# **Green Hill Solar Farm**

## **EN010170**

### **Change Application and Consultation Report**

Document Reference: CR1/GH9.2

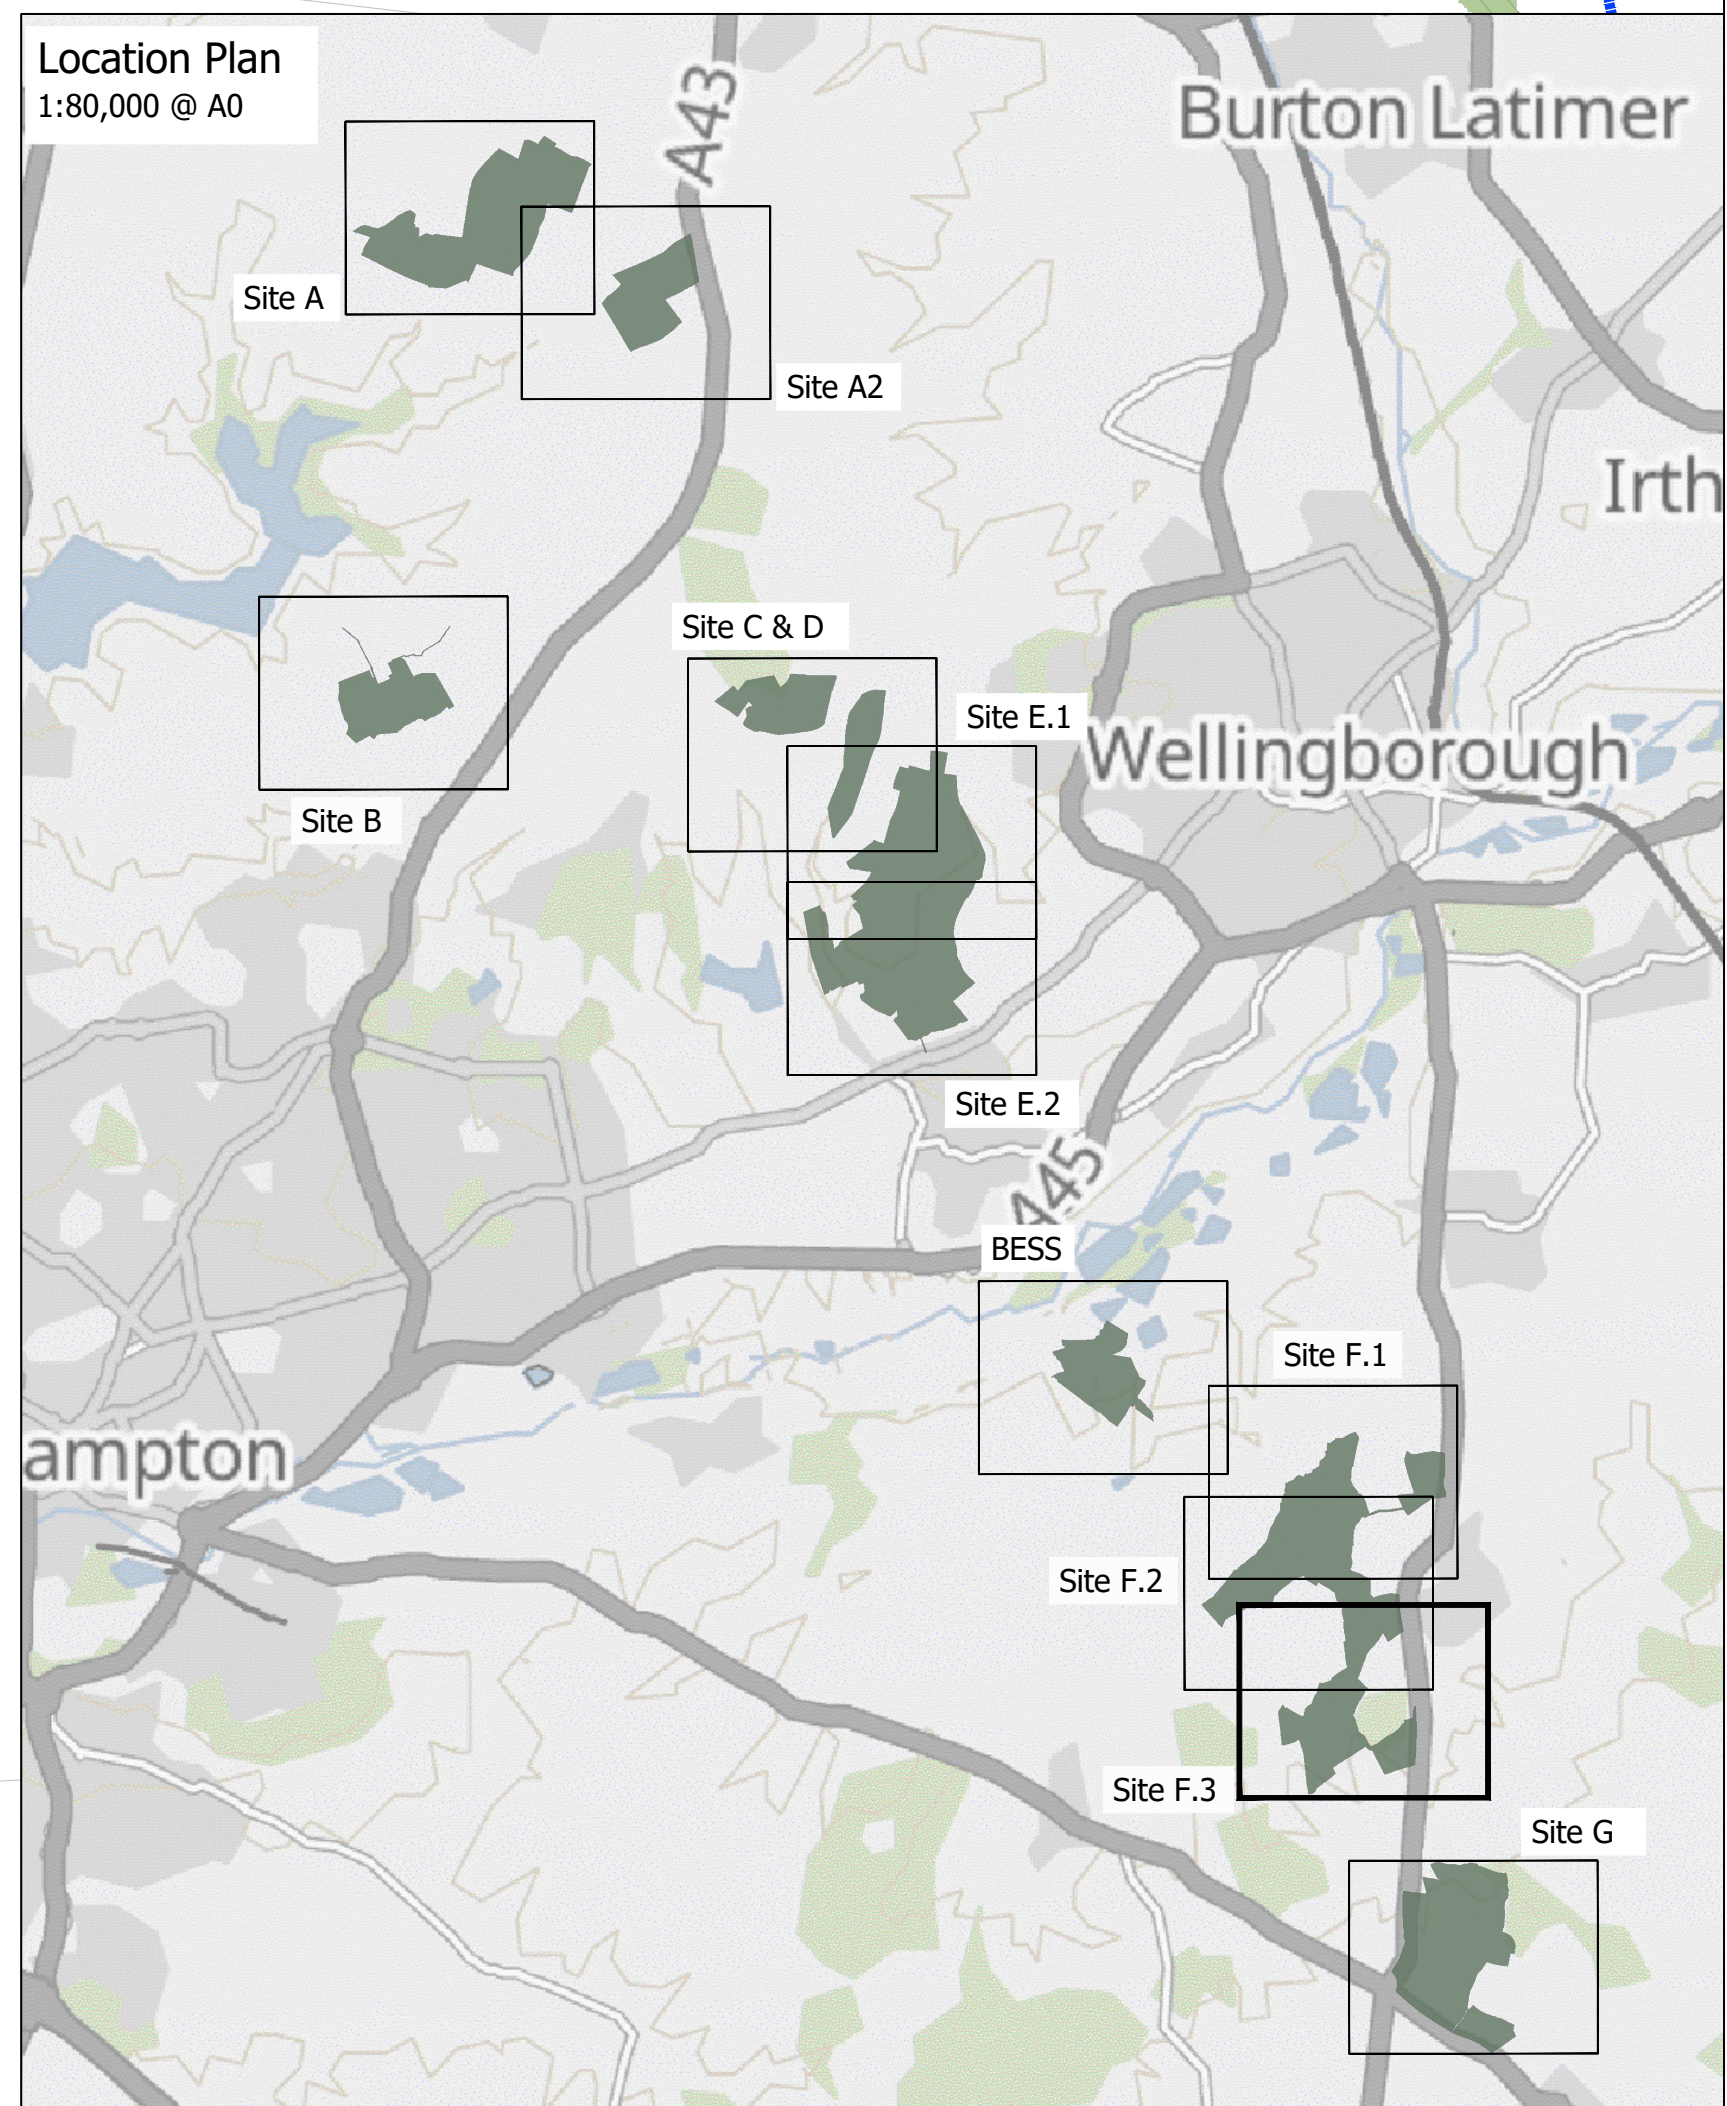
- 3.10.3 Firstly, it is proposed that the compulsory acquisition status of an area to the east Horn Wood is increased from temporary possession powers (yellow) to permanent acquisition of rights only (blue) on the Land Plan by reducing the size of plot 16-210-a and by creating a new plot 16-210-c in the updated Land Plan **[EN010170/CR1/GH2.2\_C]**. This area will also be included within Work No 8B on the Works Plan **[EN010170/CR1/GH2.4\_C]**. This will allow for the creation outside of the buffer area of an access for use during the construction, replacement and decommissioning phases. The indicative route of this access is shown on the updated ES Figure 4.19 Landscape and Ecology Mitigation Plan F Sheet 3 **[EN010170/CR1/GH6.4.4.19\_B]**. The affected area extends to approximately 1.07ha.

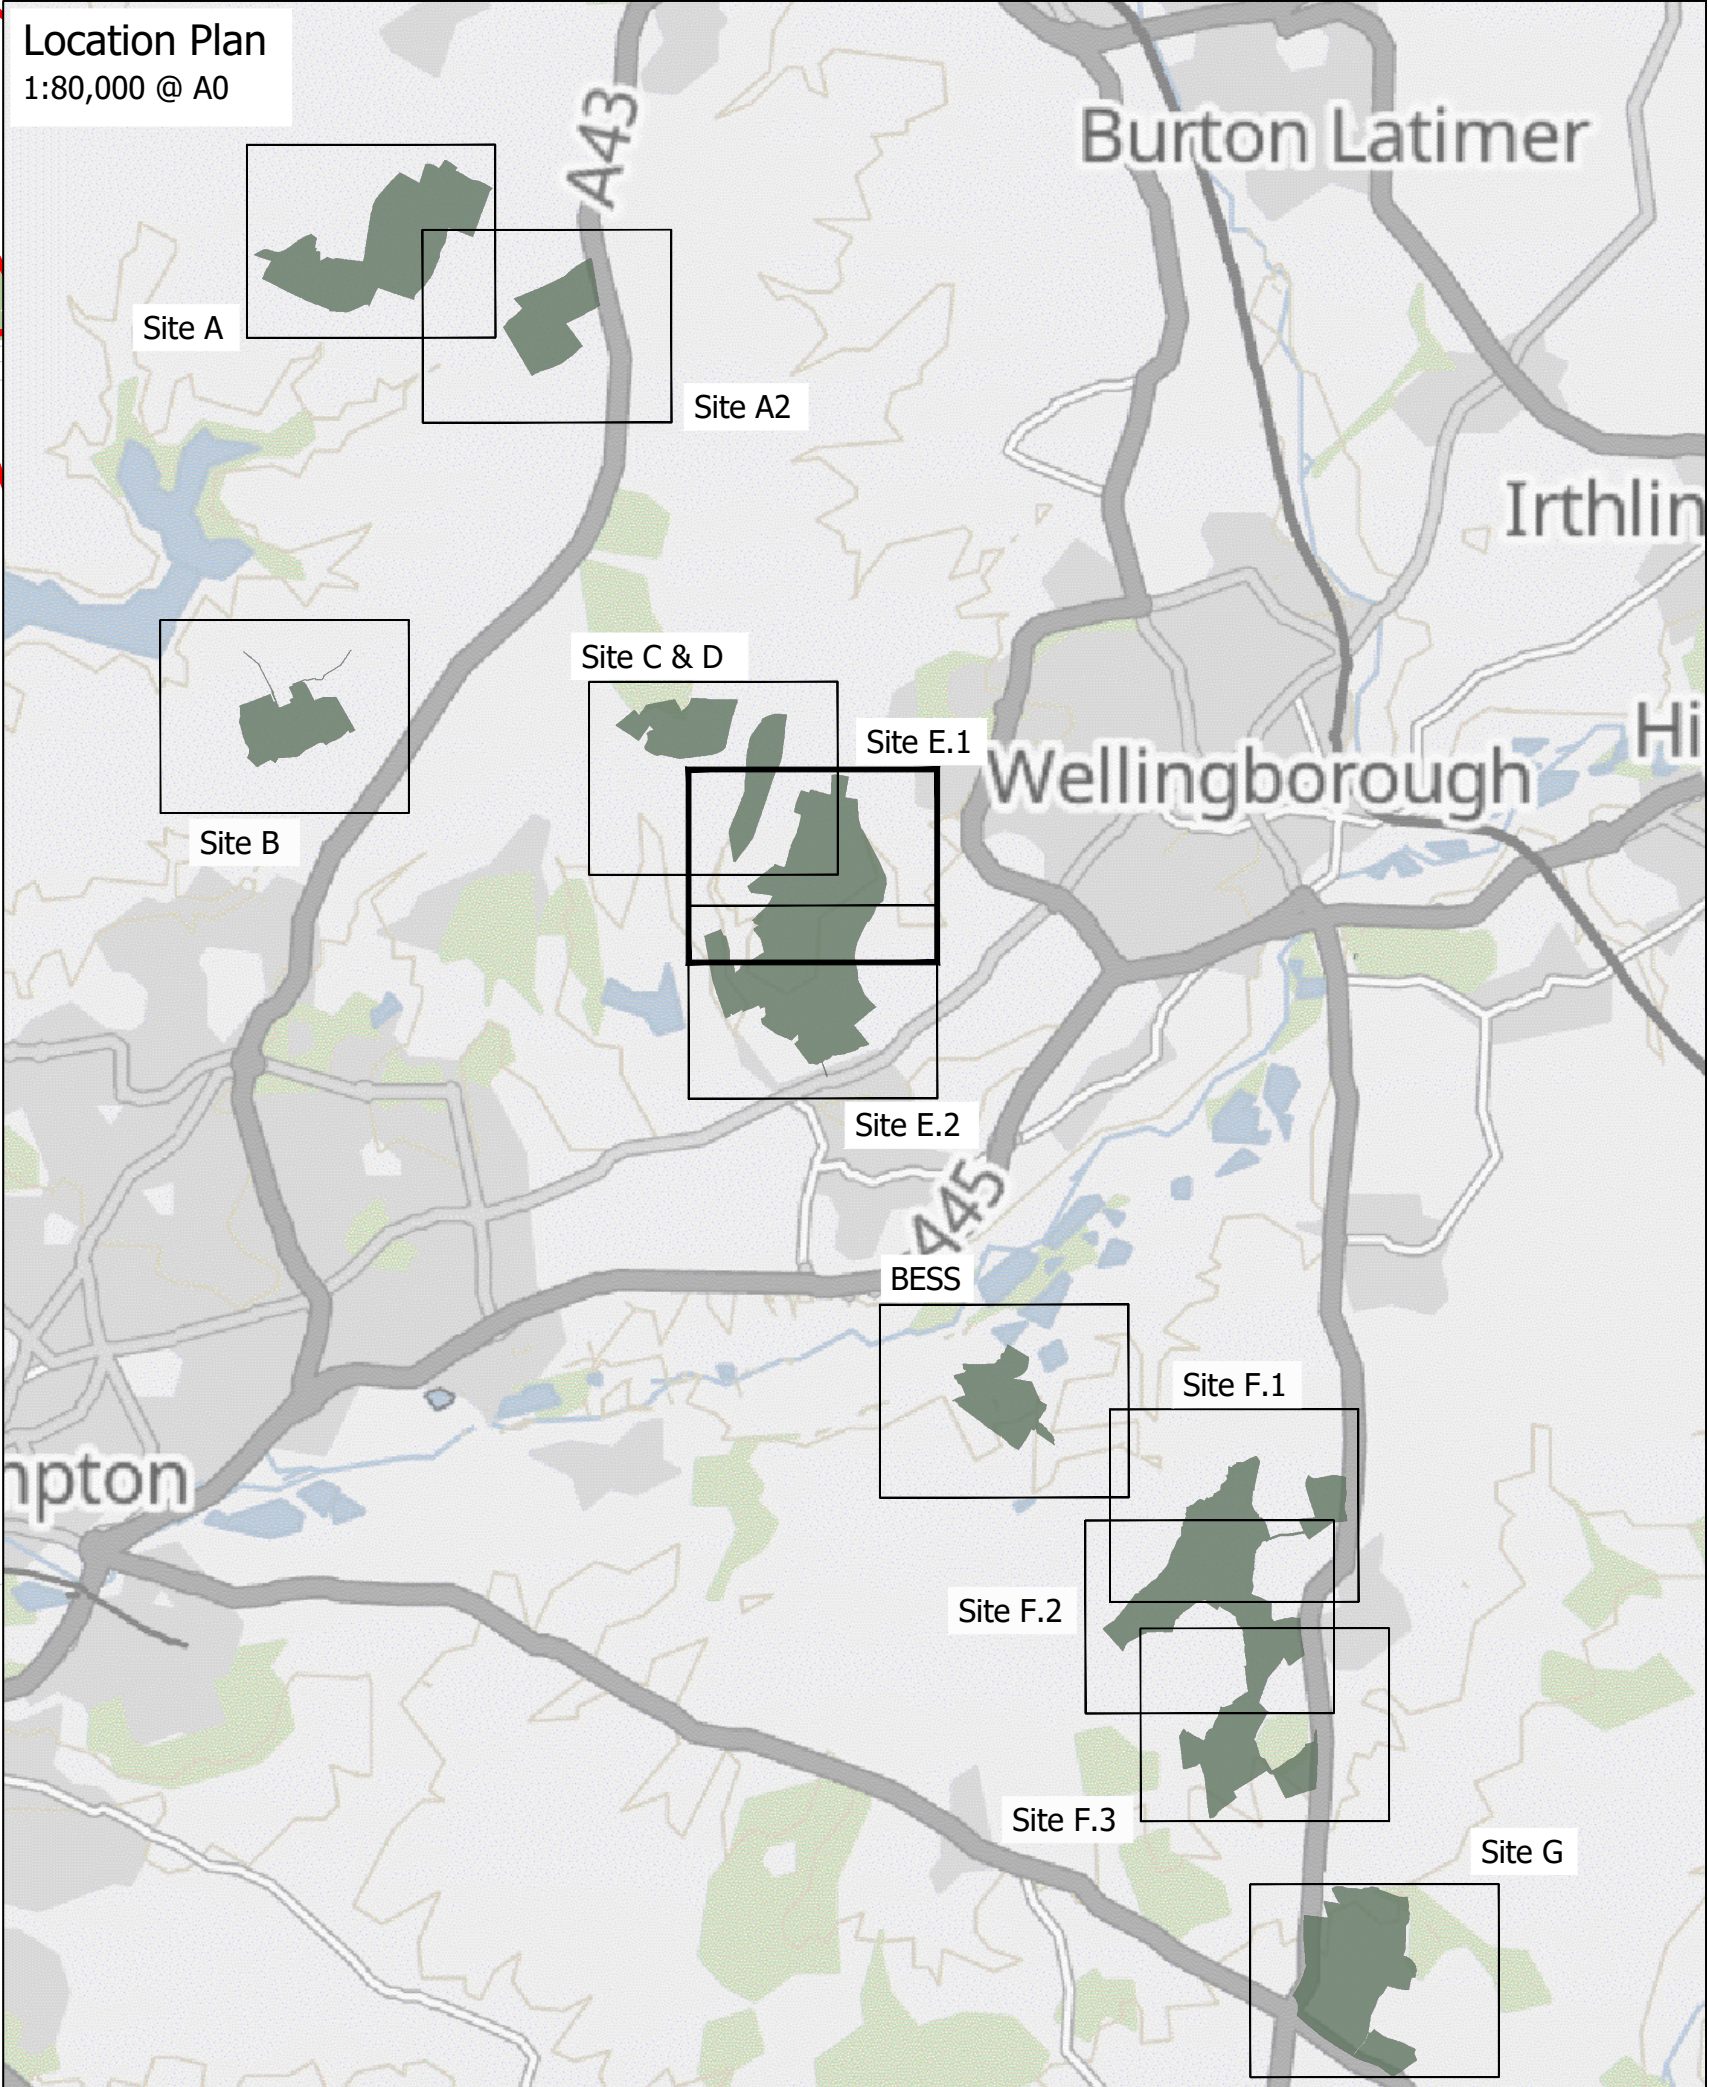
- 3.7.1 Change 6 comprises an extension to the Order Limits on the western side of Green Hill E. A detailed post-submission review by the Applicant of the proposed permissive paths within the Scheme indicated that the proposed permissive path within Green Hill E did not adjoin a publicly accessible route. This change is proposed to connect the permissive path to Byway Open to All Traffic, reference TN/010, allowing members of the public to reach the new permissive path from the public highway without having to cross private land. The area of the land to be added to the Order Limits is approximately 0.03ha. This land, forming new plot 08-089-b, will be subject to compulsory acquisition of the freehold and shown in pink on the updated Land Plan [EN010170/CR1/GH2.2\_C].

Figure 4.17 Revision B
Green Hill Site F (1)
Landscape and Ecology Mitigation Plan
[EN010170/EX3/046.4.4.17_B]
5(2)(a)

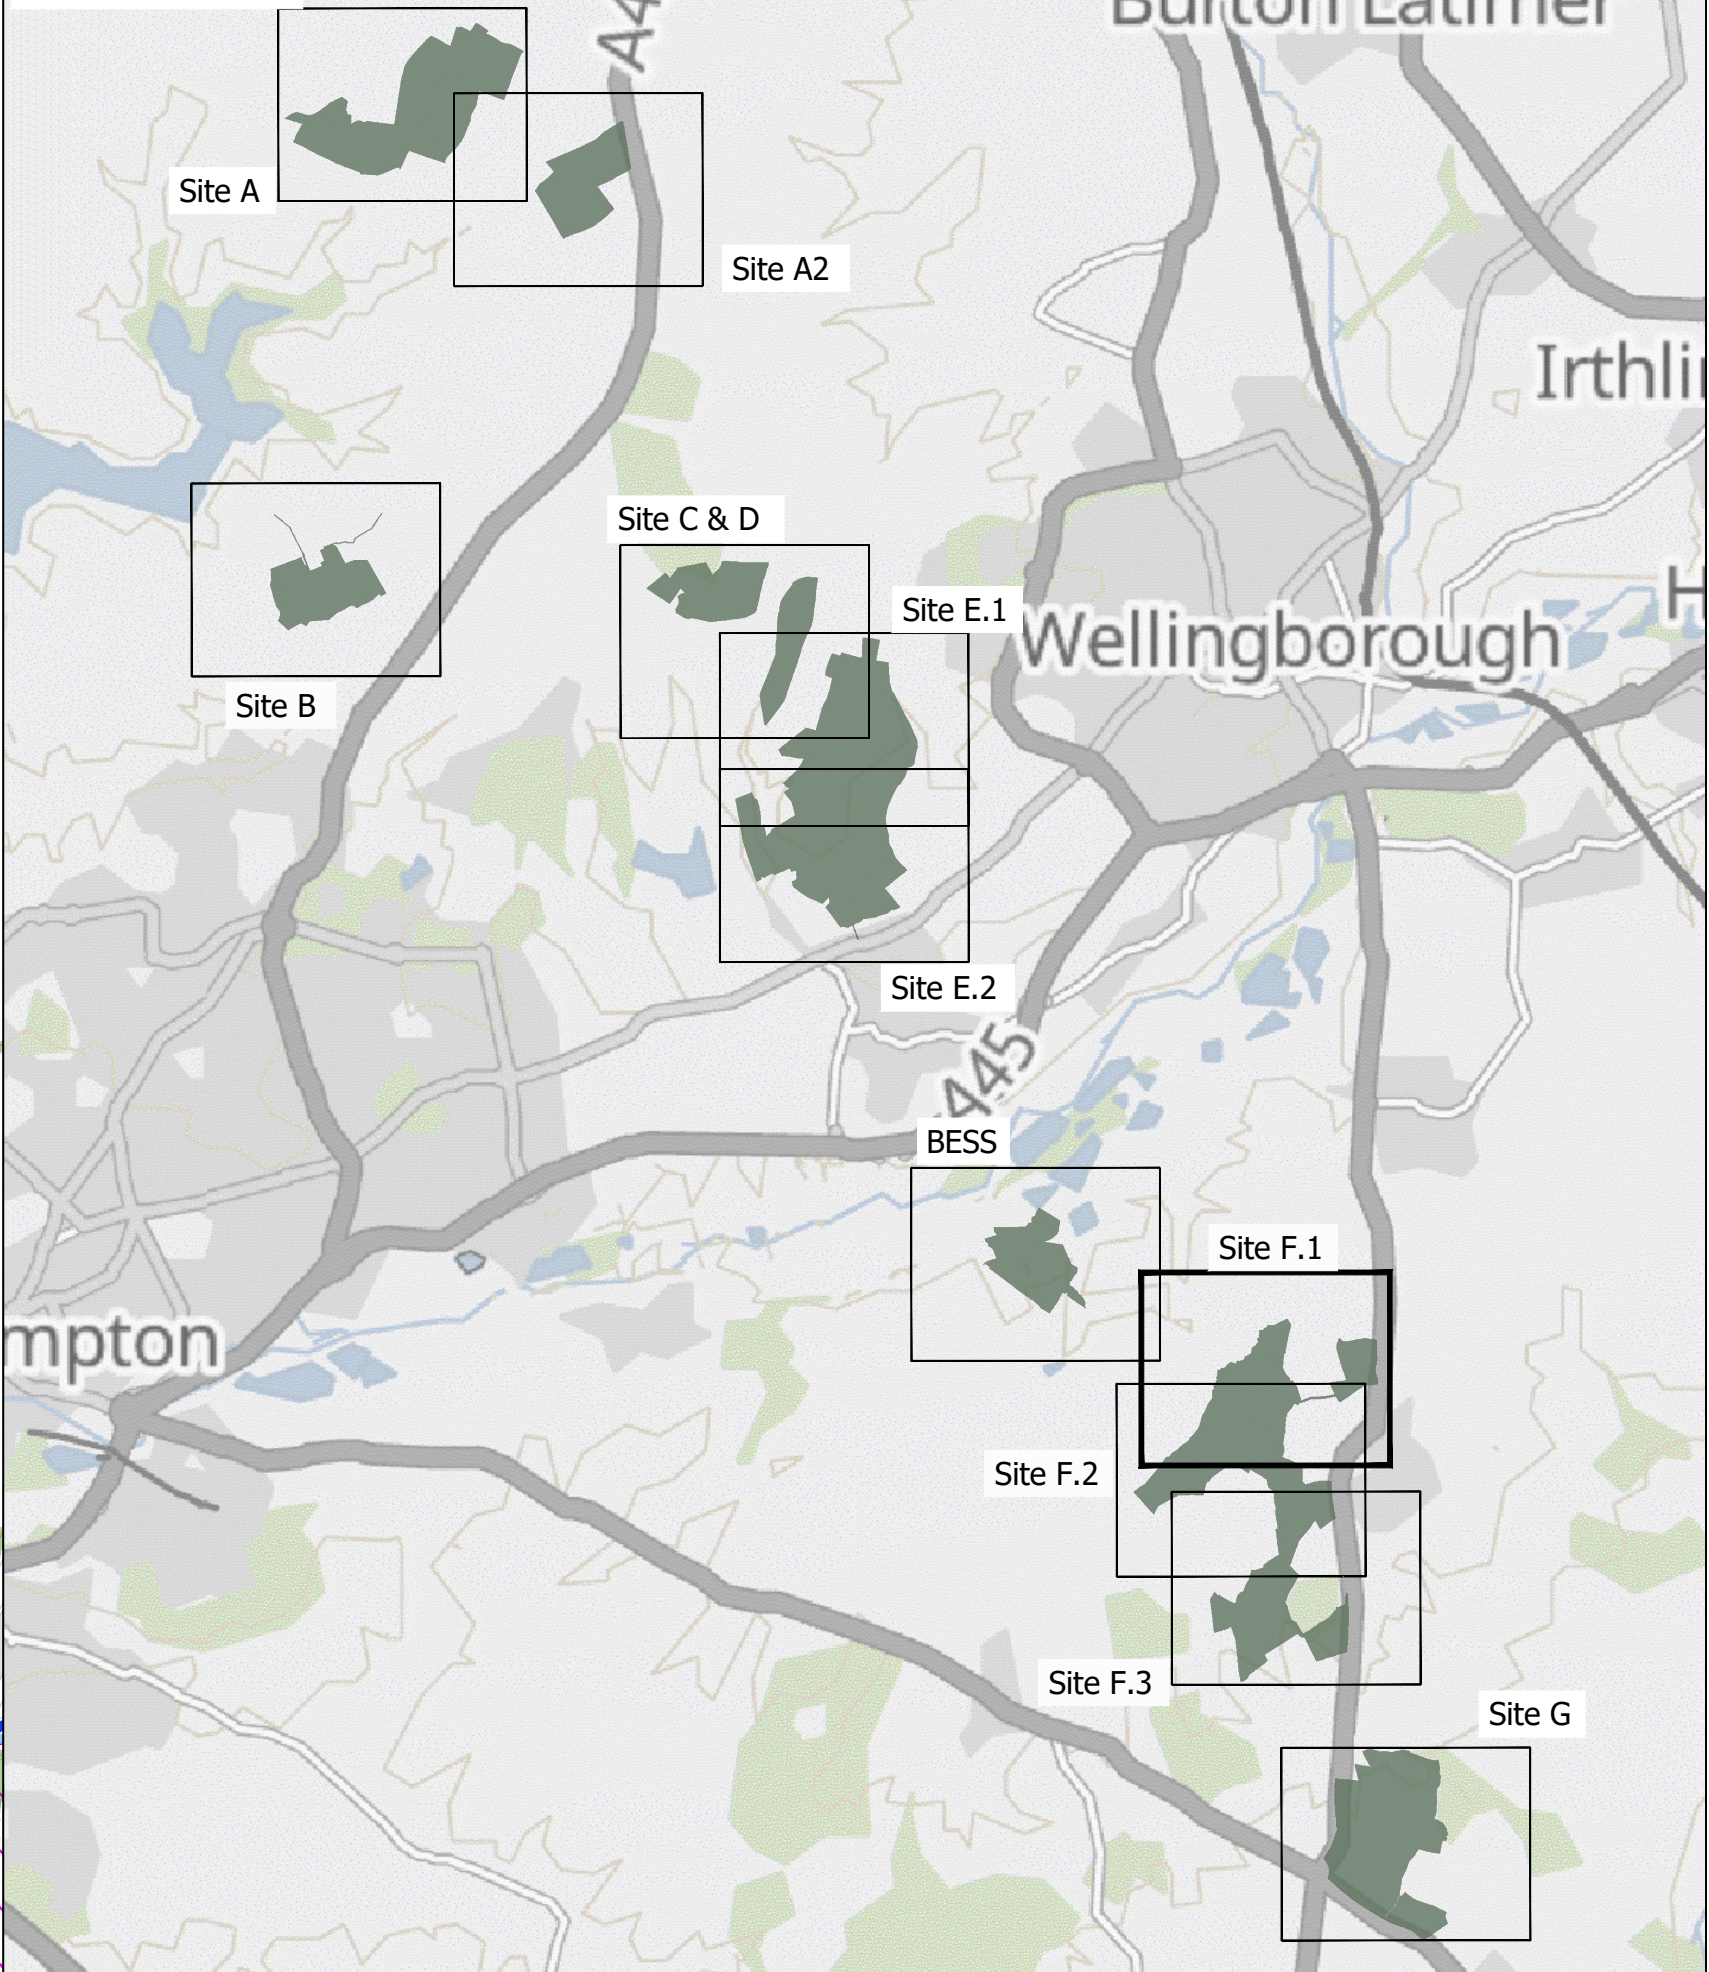
- 3.9.2 A post-submission review by the Applicant of the land plans along this watercourse indicated that a small area of land within plot 14-194 extending to approximately 0.03ha was separated from Green Hill F by the watercourse and therefore could not viably be incorporated into the Scheme. It is therefore proposed that this area of land be removed from the Order Limits, as shown in the updated Land Plan **[EN010170/CR1/GH2.2\_C]** and Works Plan **[EN010170/CR1/GH2.4\_C]**.

CR1/GH6.4.4.17_A	ES Figure 4.17 Landscape and Ecology Mitigation Plan F Sheet 1	Update in relation to Change 8
CR1/GH6.4.4.19_B	ES Figure 4.19 Landscape and Ecology Mitigation Plan F Sheet 3	Update in relation to Change 9
